Response to Submissions – MP10_0098 MOD 1 Royal Randwick Racecourse

This letter has been prepared to respond to the matters raised by Randwick City Council and Transport for NSW during the notification period for MP10_0098 Mod 1. Firstly we make no further comment regarding the submission received from Transport for NSW and thank Mark Ozinga for his response.

Figure 3: Proposed construction staging plan

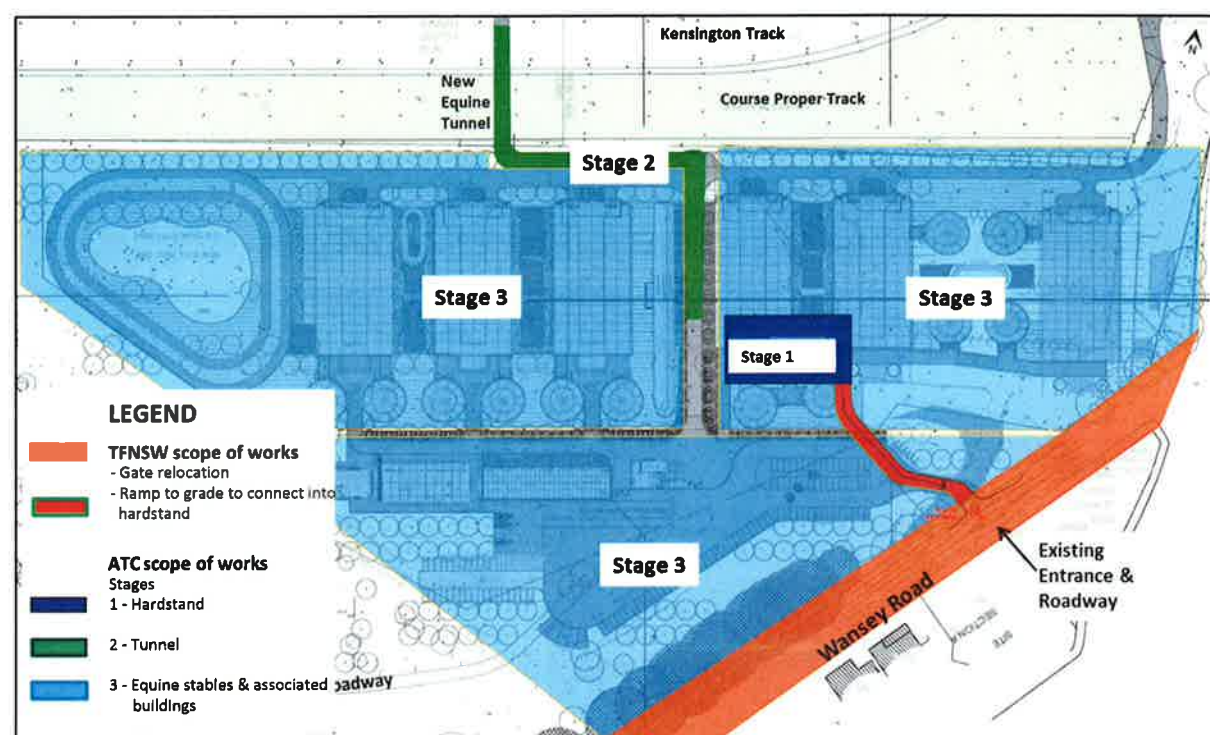
- Please refer to a revised Construction Staging Plan included at Attachment 1 which confirms that for the purpose of this Modification, Stage 3 is to be undertaken in one stage (as the final stage of works).

- This amendment to the Construction Staging Plan also addresses the Council's other comments regarding Stage 2 or 'subsequent stages' and we take the opportunity to clarify that there are only three stages proposed (excluding Transport for NSW works). Please refer to the revised Schedule of Amendment Conditions at Attachment 2, which clarifies the intention of the 'subsequent stages' as referenced within the S75W Report.

Drawing No.	Revision	Name of Plan	Date
		SK-003	Issue 5	Construction Staging Diagram	06/11/2015
New Condition A2A Development in accordance with staging plan	This request includes the provision of a ‘Construction Staging Plan’.	Insert the following as a new condition of approval: “A2A Development in accordance with staging plan The development is to be undertaken generally in accordance with the stages as shown on the Construction Staging Plan submitted with the modification request (MP10_0098 MOD 1), and any reference in this approval to any Stage is a reference to the relevant stage as shown on this plan.”			
Council comment: Clarification of the works encompassed within the proposed stages is considered necessary. Applicant response: This detail is provided within Section 4.2 of the S75W Report. This response to submissions further clarifies that Stage 3 is to be constructed as one stage of works.
